J.S. THOMPSON
ENGINEERING, INC

August 13, 2025

The plan was reviewed for lot #3 Ilas Way subdivision in Dunn, North Carolina to address the framing at the transom window in the master bathroom.

SECOND FLOOR PLAN
SCALE 1/4" = 1'-0"

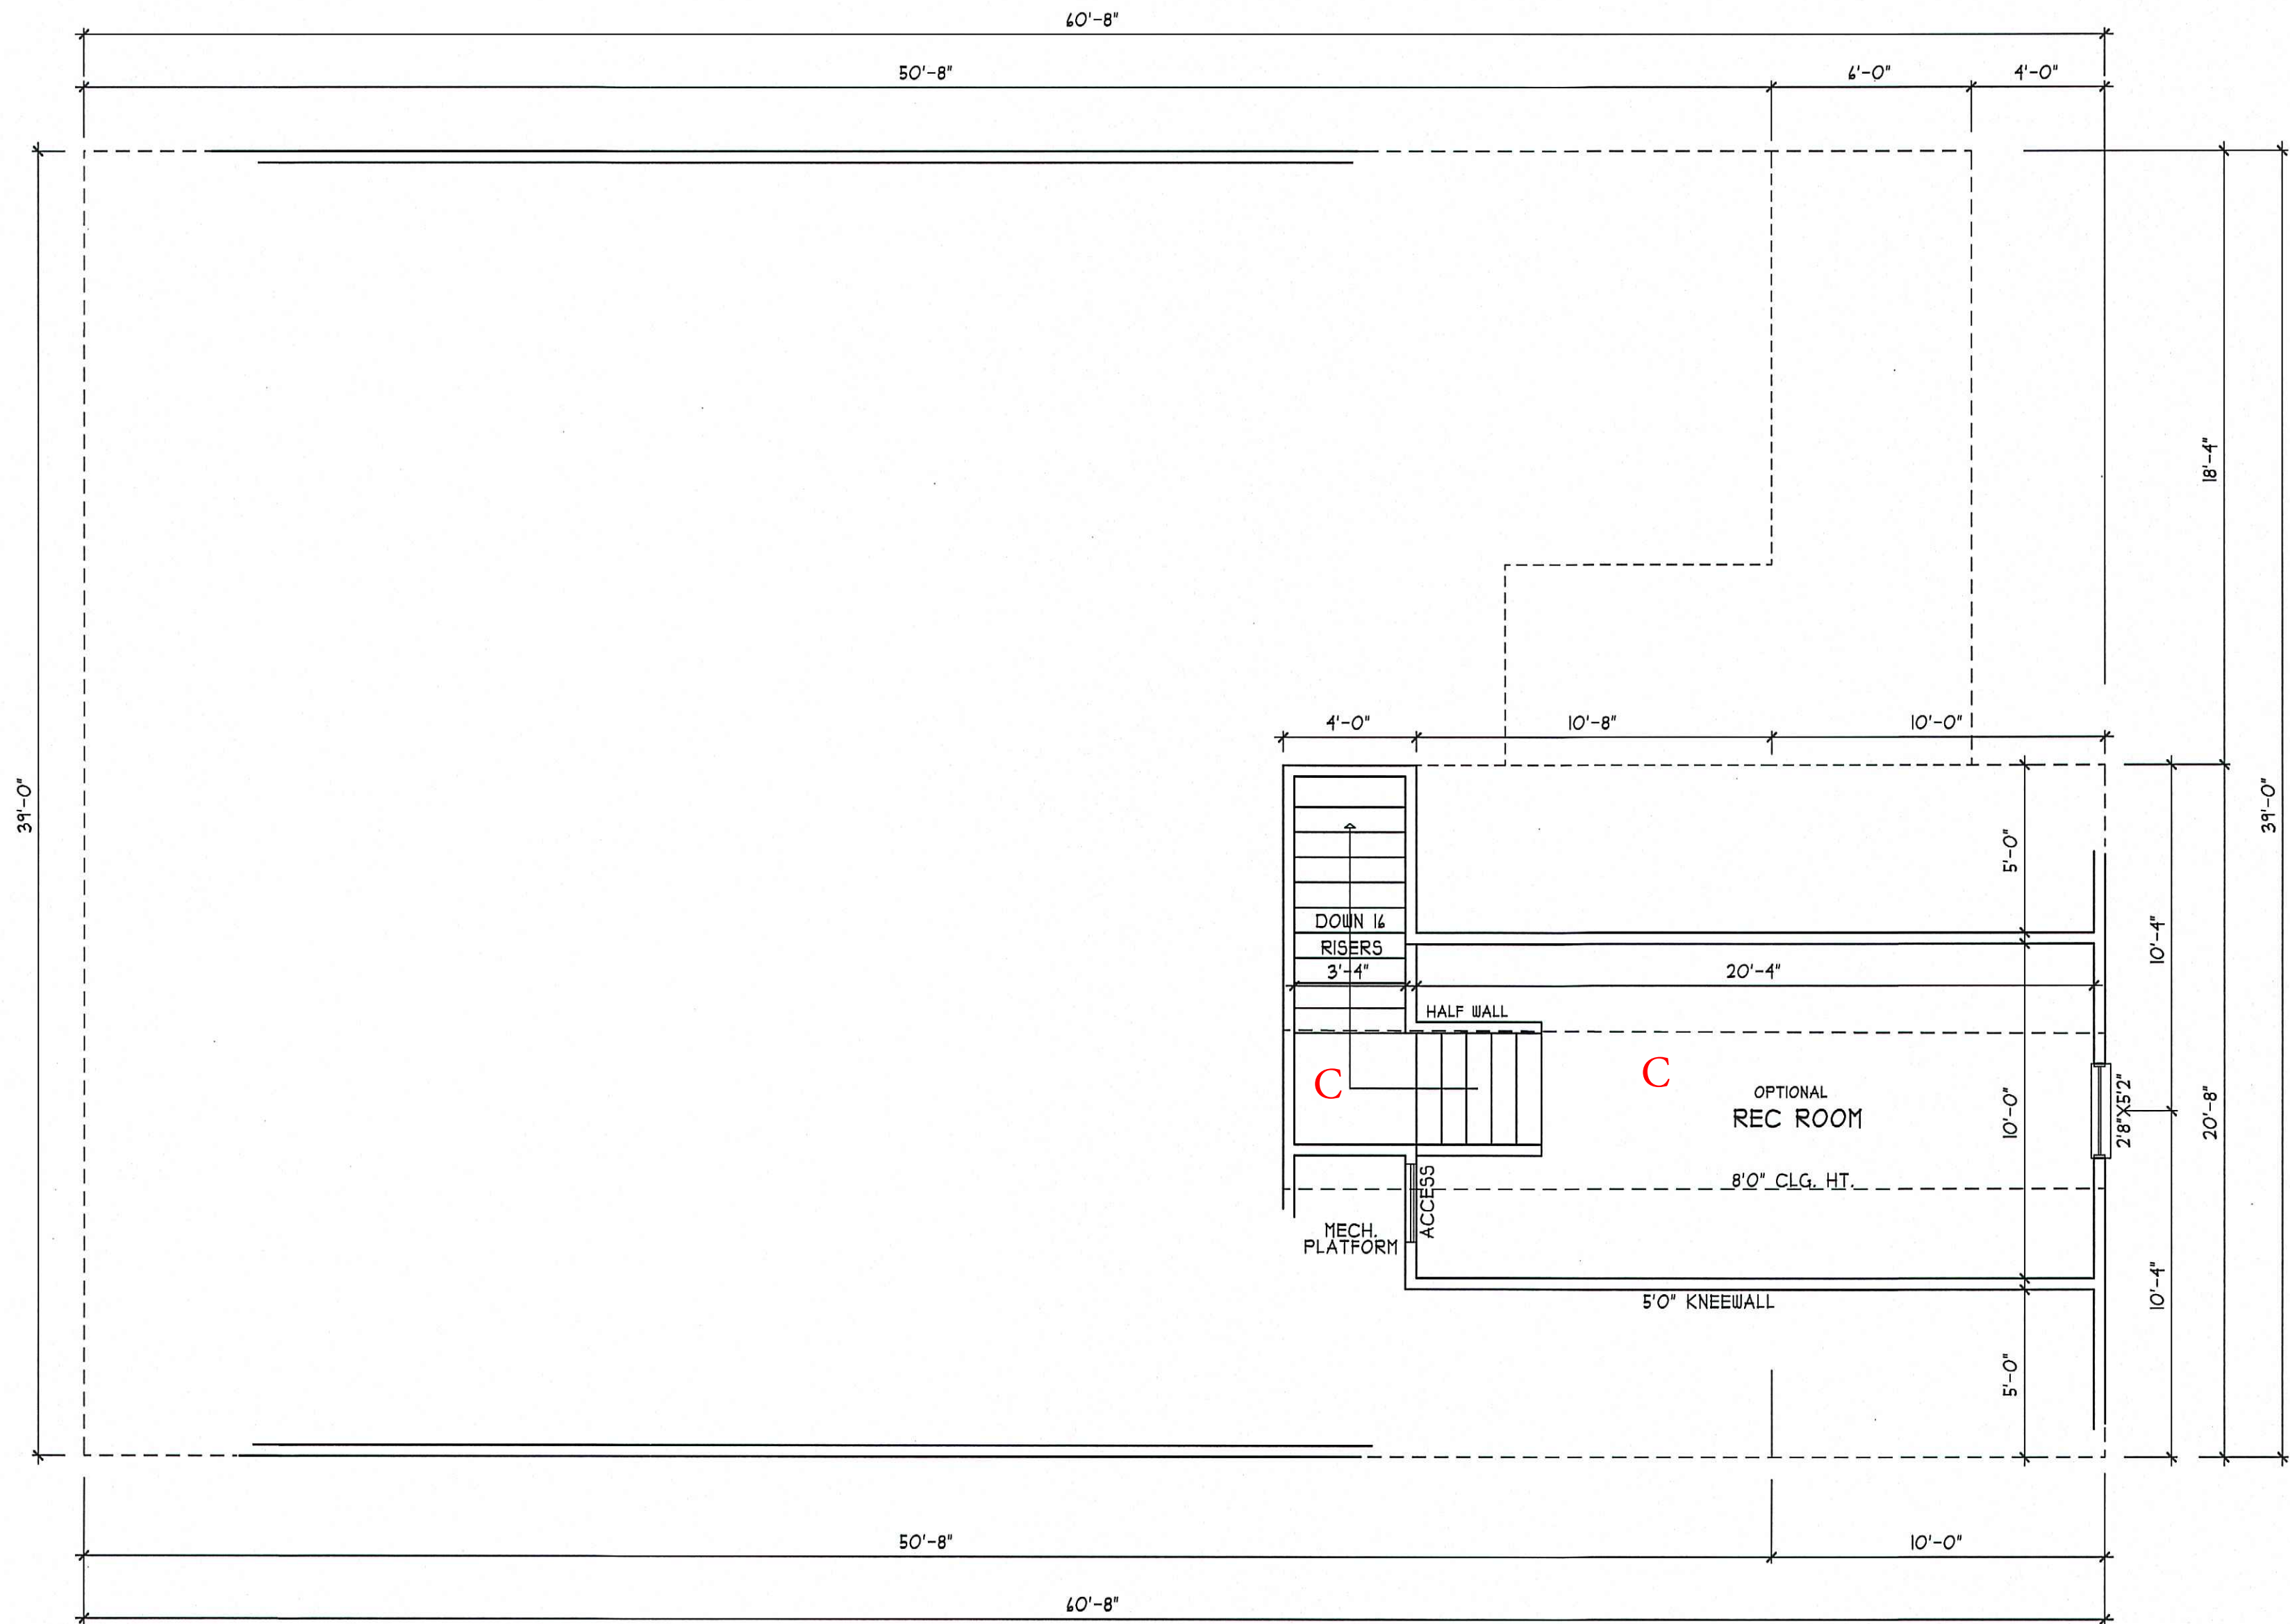
Per the builder, the window was raised above the shower to be tight beneath the top plates. The nailer is to be removed and a 2 x 10 SPF #2 ply is to be fastened to the bottom chord of the gable end truss above with (2) rows of 12d nails at 6" o.c. The added ply is to extend a minimum of 4" past the window. This configuration will provide the required support for all applied loads.
